From: Anita Gardner <Anita.Gardner@arun.gov.uk>
Sent: 03 June 2020 08:48
To: Planning.Responses <Planning.Responses@arun.gov.uk>
Subject: FW: M/37/20/NMA - Little Thatch, Middleton Road

I've started looking at the above application to assess if I can accept it as an NMA, but I can't scale the following 3 plans : Section, Sheet 2 West Elevation or Sheet 3 North Elevation which don't have a scale, although there are some measurements given. The only plans which have a scale don't have a measure tool bar appearing so that I can scale them electronically. I would therefore appreciate floor plans and elevations of the existing and proposed conservatory so that any differences are clear and dimensioned.

PLAN

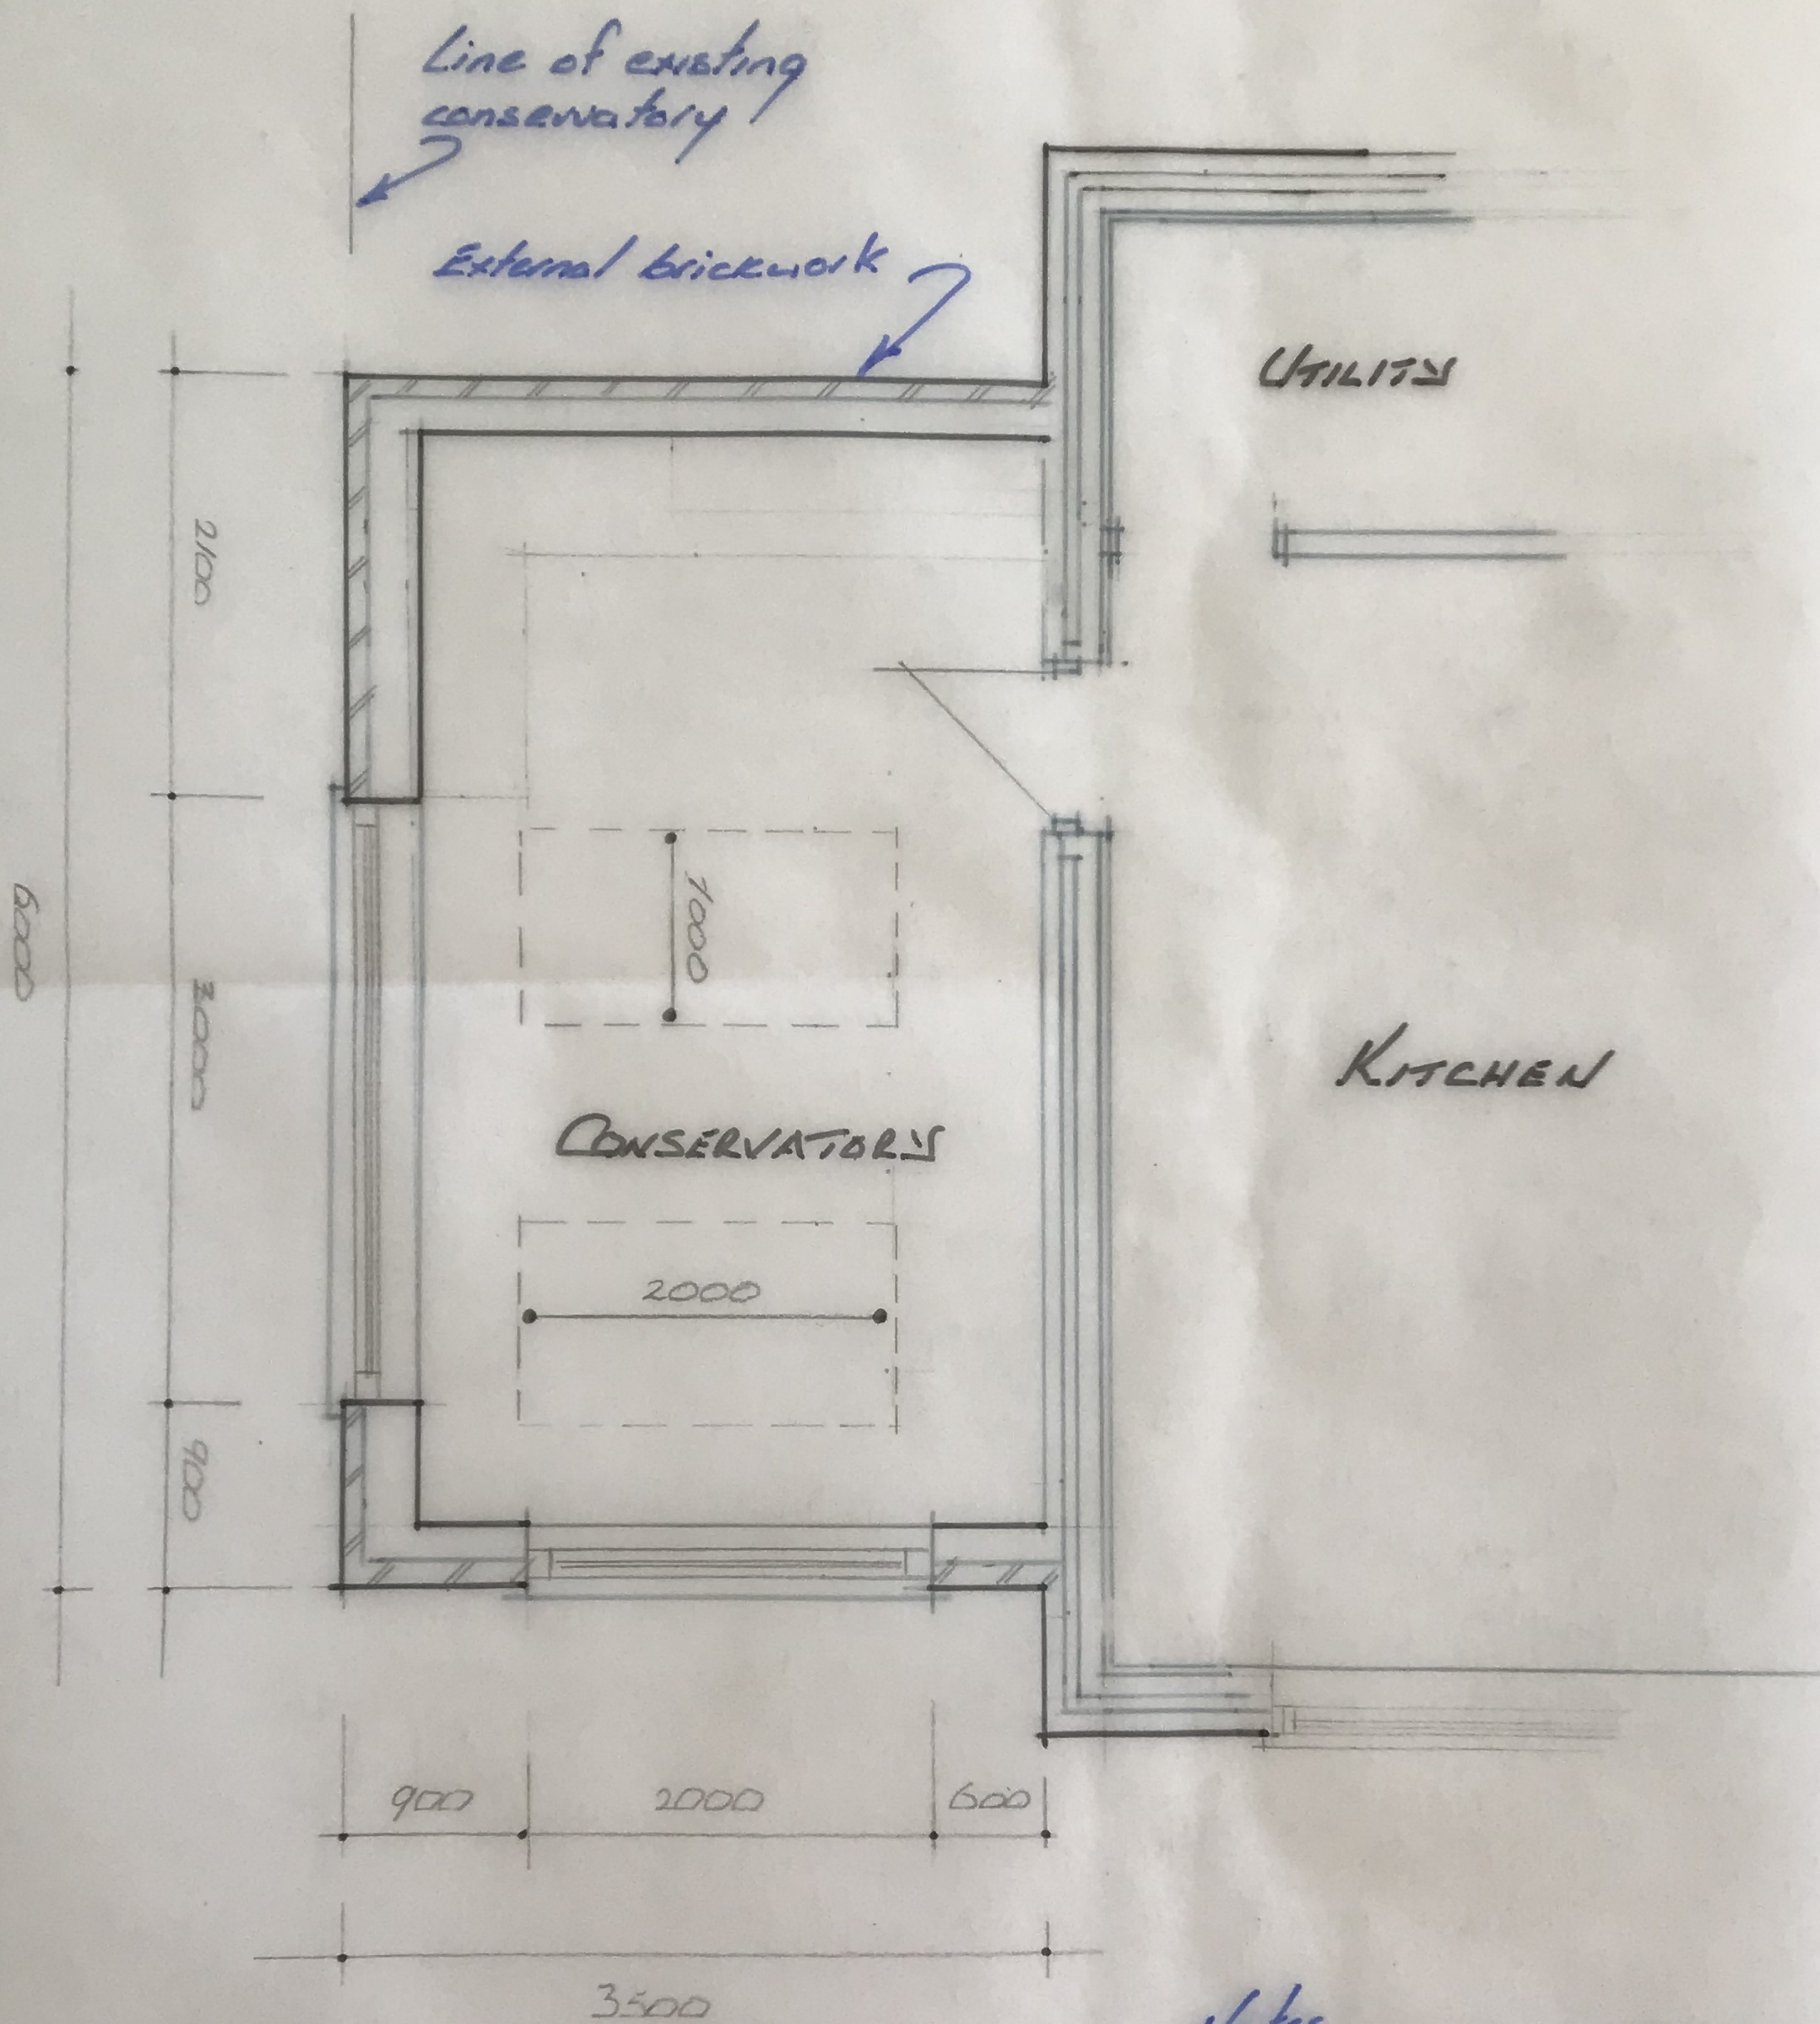
To clarify, all of the dimensions, size and location of the conservatory remain as per the approved application. The change is only to remove the lantern light which was proposed to run East to West across the flat roof and replace it with two low level fixed skylights running North to South within the roof construction. I dimensioned the Plan to show the location of the rooflights within the space as requested by Nicola.

I propose removing the lantern light to reduce the overall height of the structure. The lantern light on the approved plans is considerably higher than the flat roof. It also significantly simplifies the construction as the rooflights now follow the roof slope within the joists and it will reduce costs. The proposed rooflights are the same design and manufacturer as the one approved for the adjoining kitchen on the previous NMA.
